Department of Primary Industries

OUT17/21553

Coleambally Solar Farm (SSD 8208) Comment on the Environmental Impact Statement (EIS)

Figure 2-1a Irrigation channel running through centre of site 2.1b. Irrigation drain through Black Box Woodland

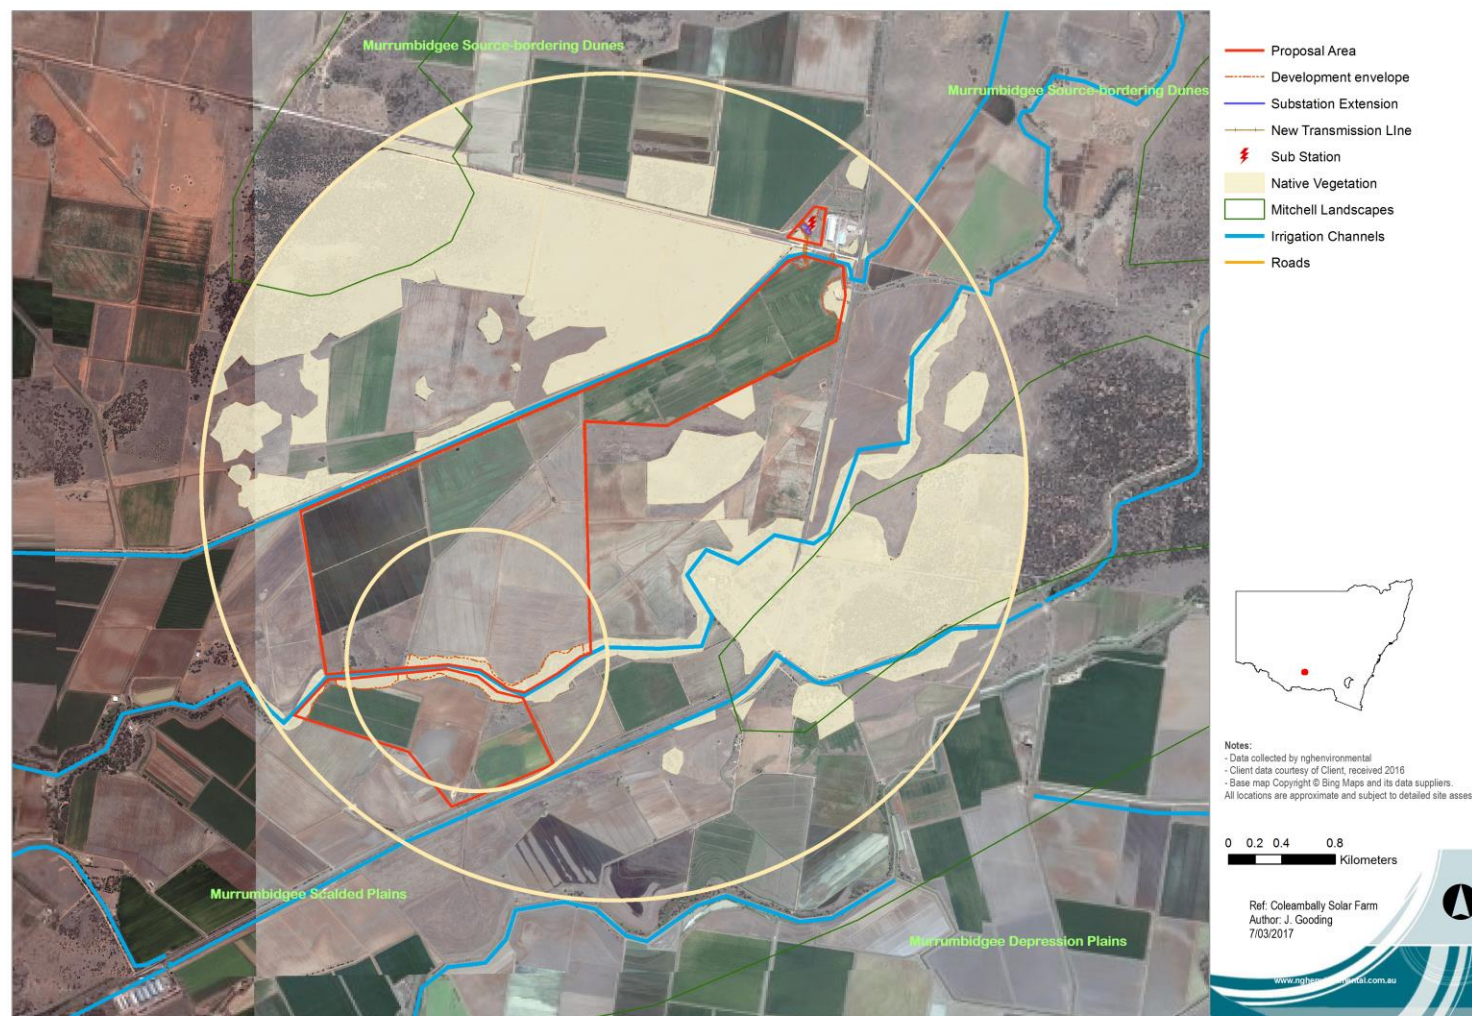
- The EIS refers to an irrigation channel that borders part of the southern project area. This channel appears to be in the location of a natural watercourse, however the EIS indicates this channel is only used for conveying irrigation flows. The proponent should confirm whether this channel also receives catchment runoff from upstream and whether this alters the potential flood impacts predicted in the EIS.

Figure 3-12 Typical trench design

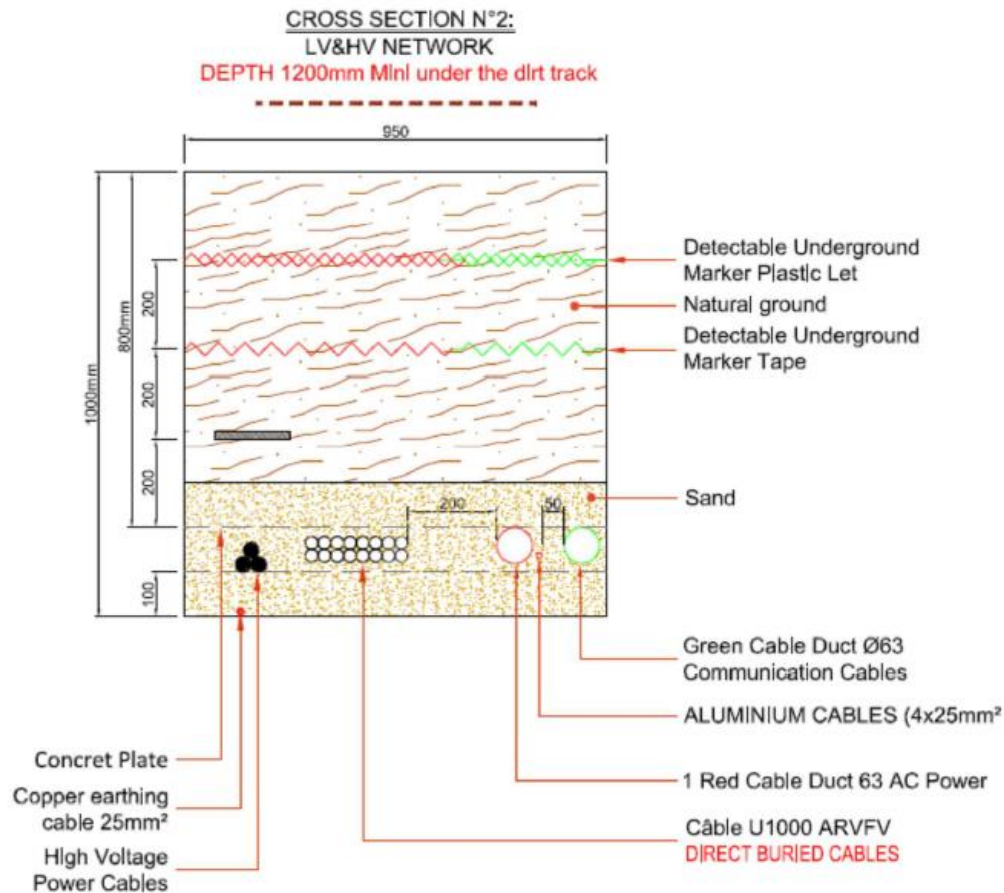
- All subsurface infrastructure should be required to be removed at the decommissioning of the project, or otherwise located at least 1200mm below ground level to ensure no future agricultural activities are impacted.
